# **EL PASO COUNTY PLANNING AND COMMUNITY DEVELOPMENT DEPARTMENT**

## **STORMWATER MANAGEMENT PLAN CHECKLIST ROLLING HILLS RANCH FILING 2**

INDEX MAP
N.T.S.

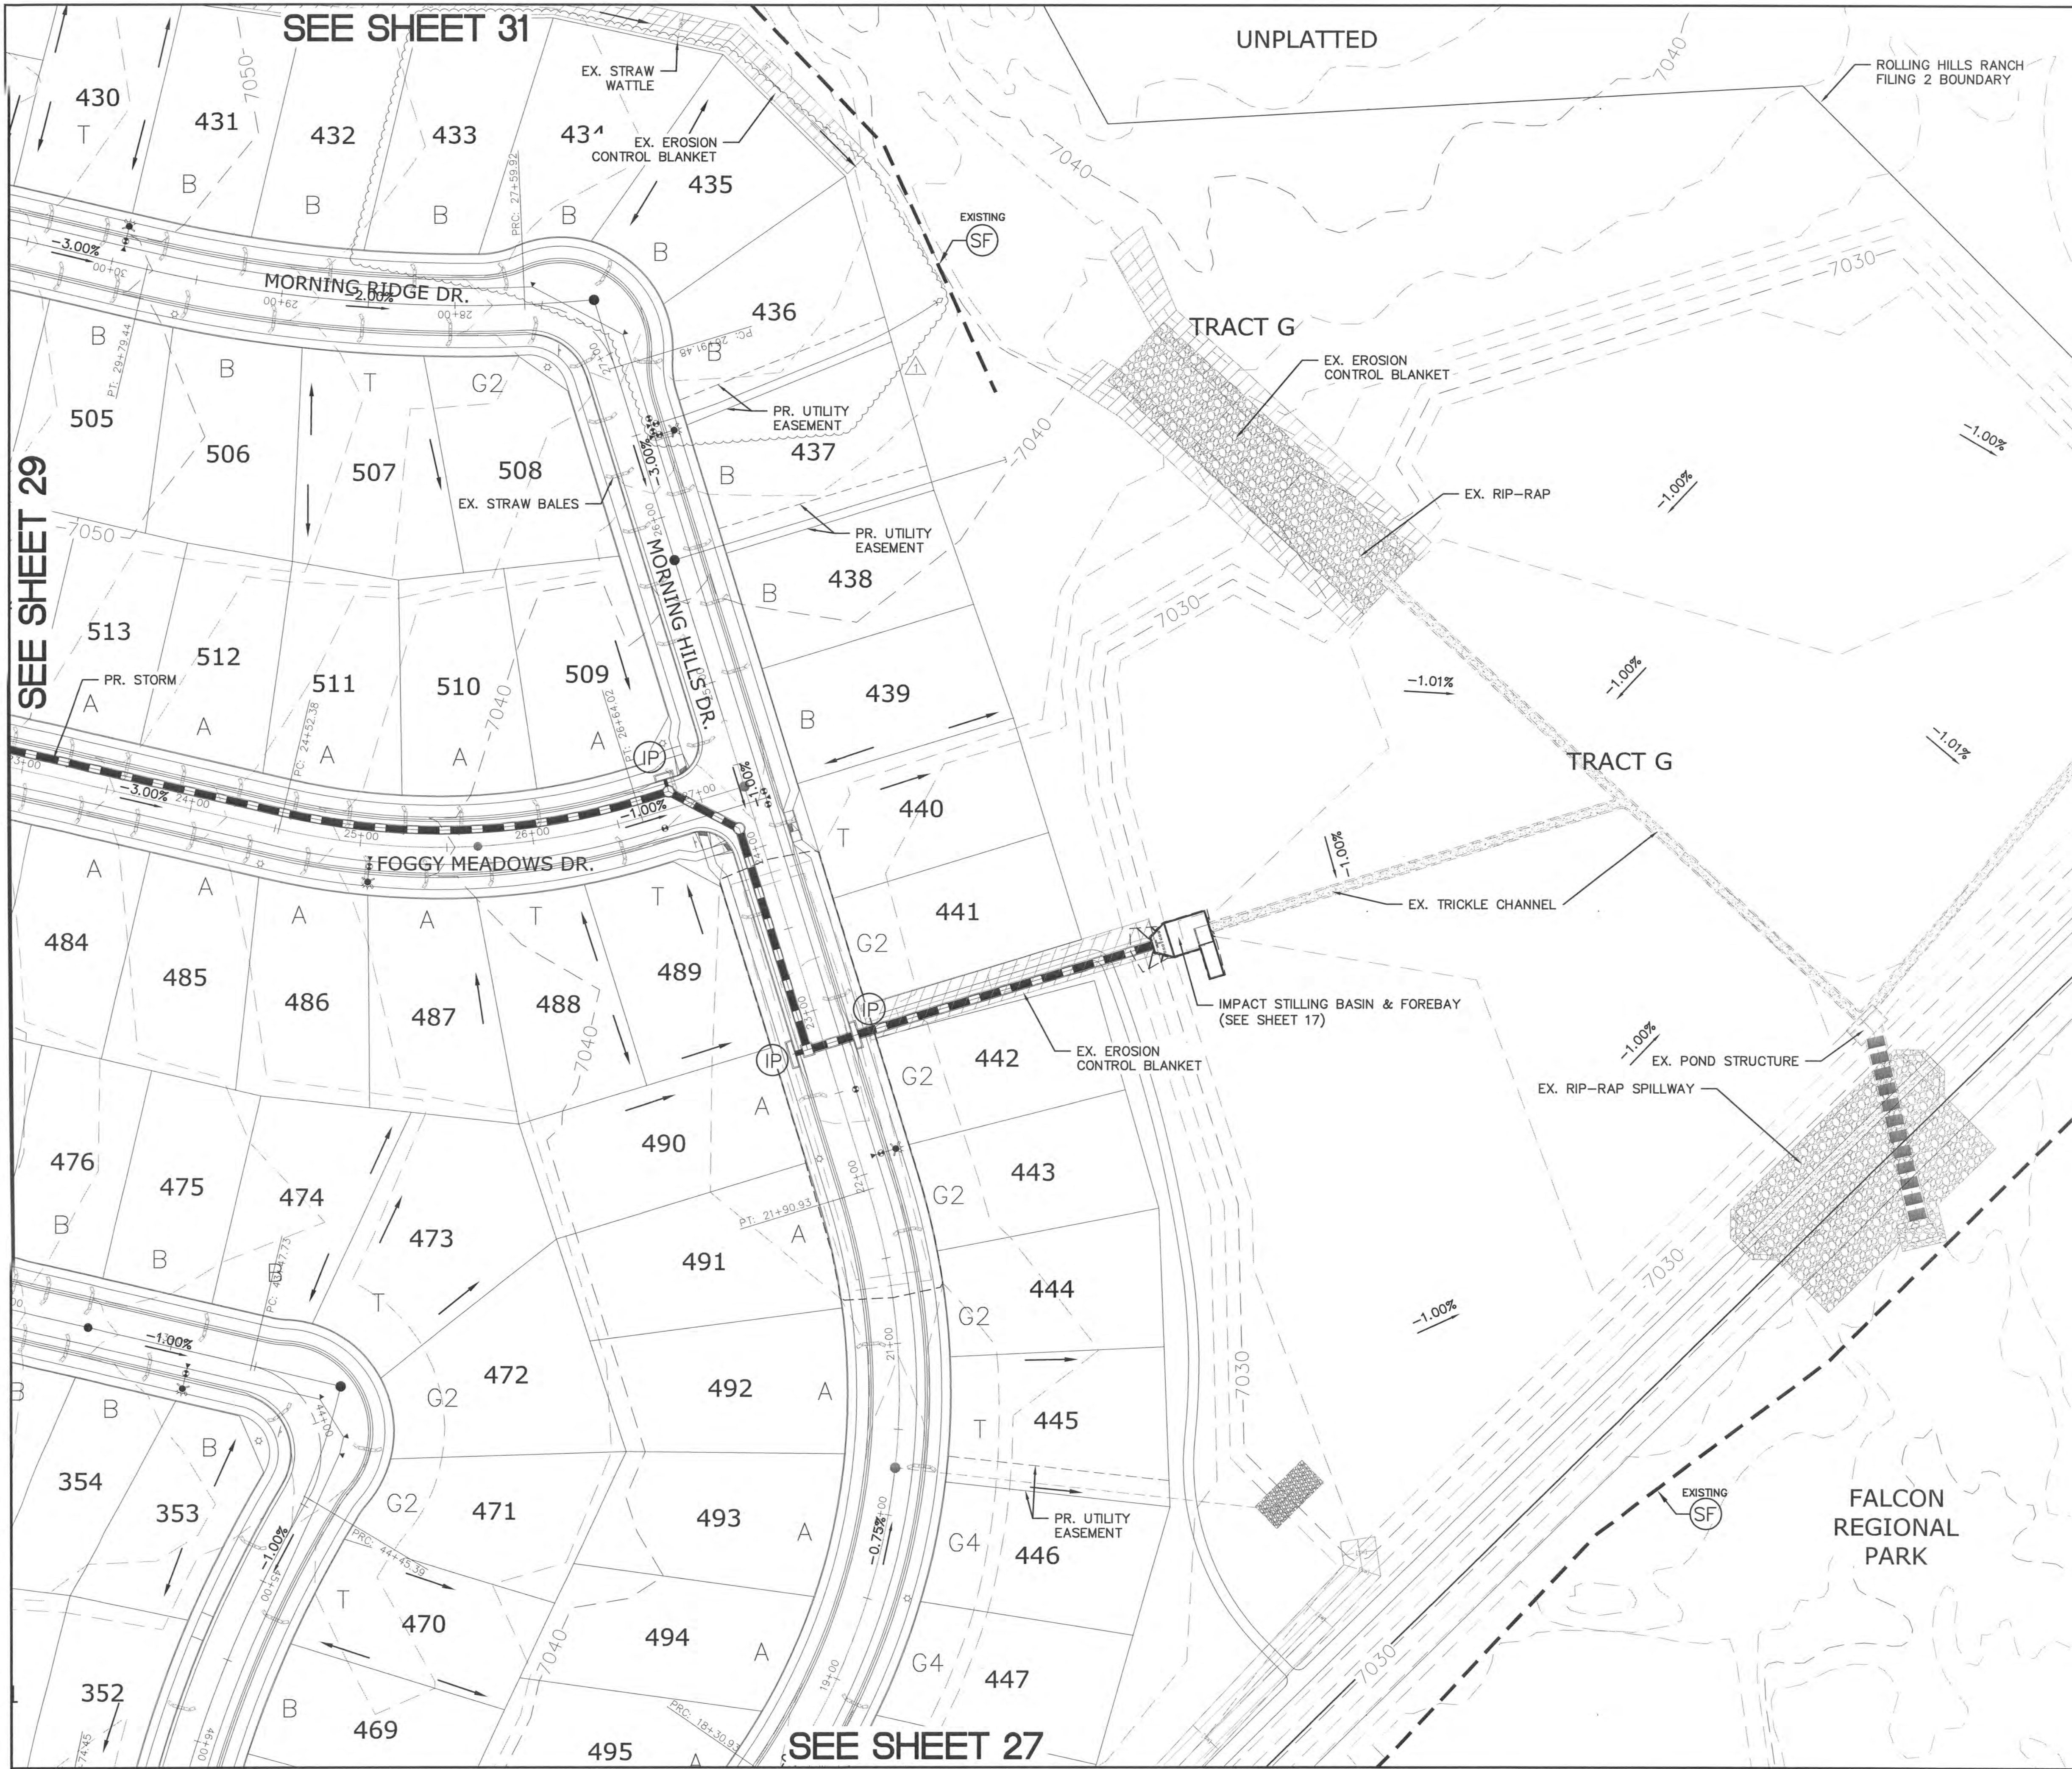
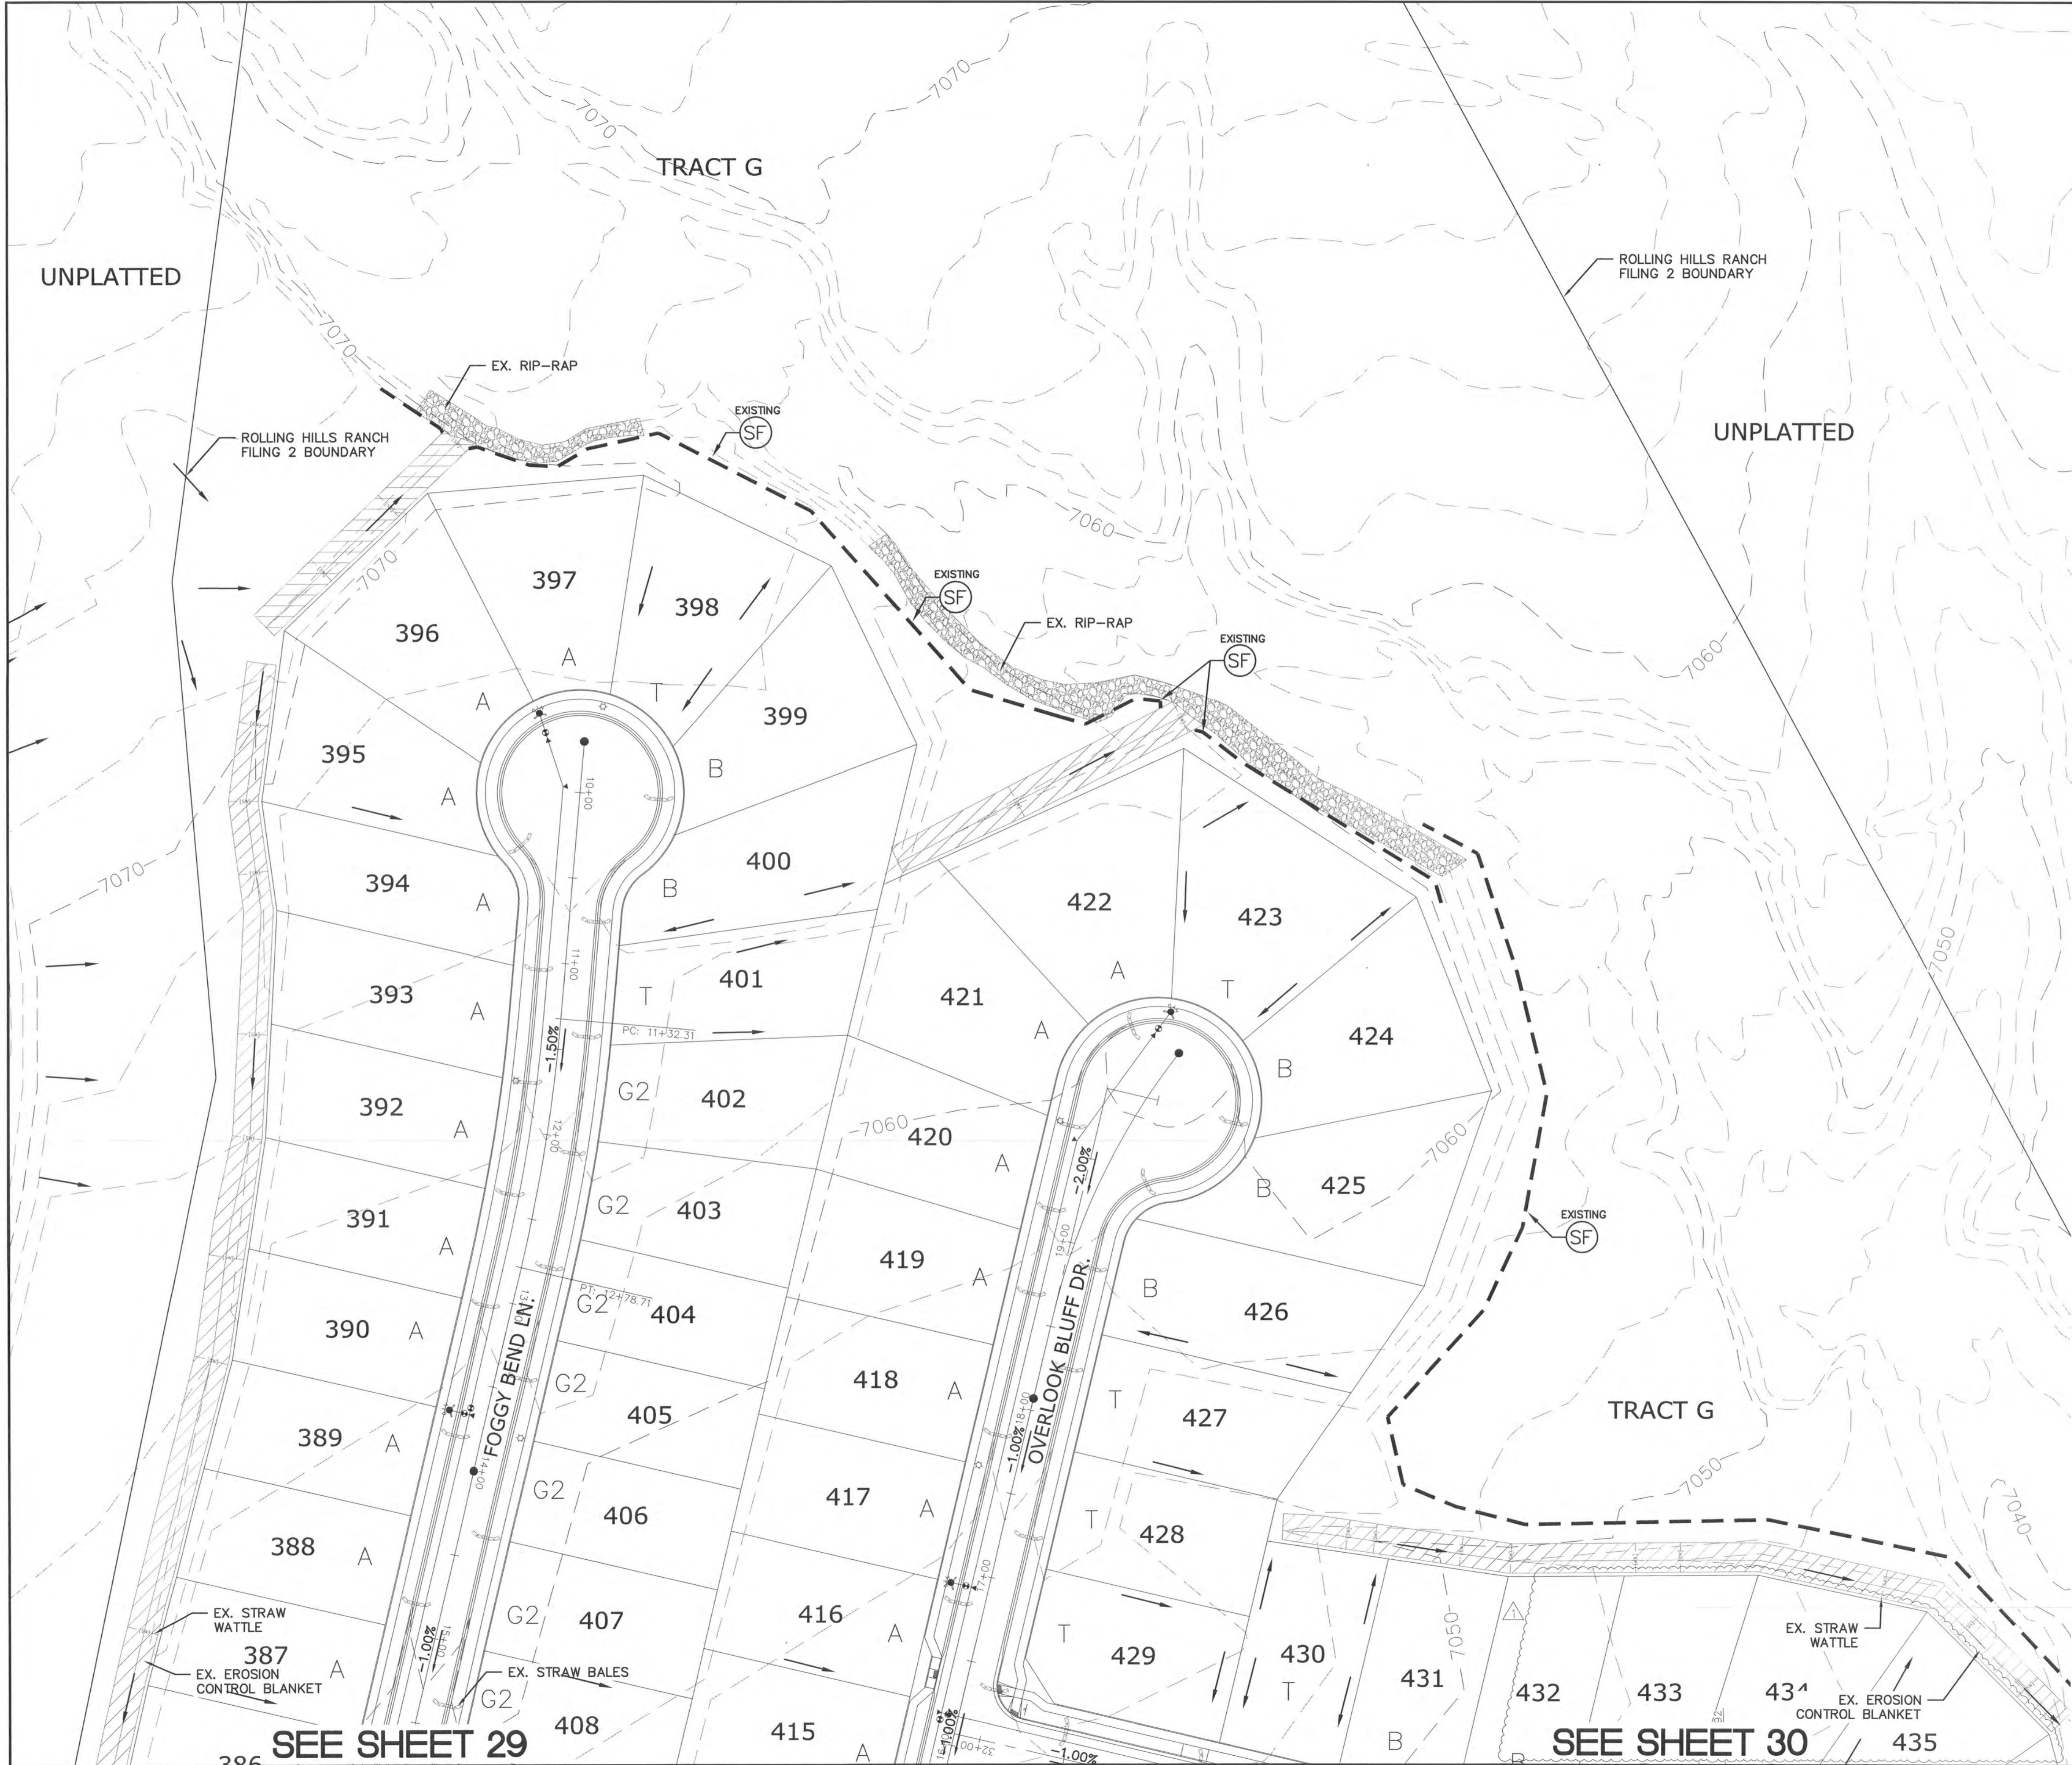
Applicant	PCD
17	SWMP Map to include:		
17a	construction site boundaries	X	✓
17b	flow arrows to depict stormwater flow directions <b>Added to sheets 27-31</b>	X	X
17c	all areas of disturbance	X	✓
17d	areas of cut and fill	X	✓
17e	areas used for storage of building materials, soils (stockpiles) or wastes	X	✓
17f	location of any dedicated asphalt / concrete batch plants <b>Note added to sheet 26</b>	X	X
17g	location of all structural control measures	X	✓
17h	location of all non-structural control measures	X	X
17i	springs, streams, wetlands and other surface waters, including areas that require maintenance of pre-existing vegetation within 50 feet of a receiving water	X	✓
18	Narrative description of all structural control measures to be used. Modifications to EPC standard control measures must meet or exceed County-approved details.	X	✓
19	Description of all non-structural control measures to be used including seeding, mulching, protection of existing vegetation, site watering, sod placement, etc.	X	✓
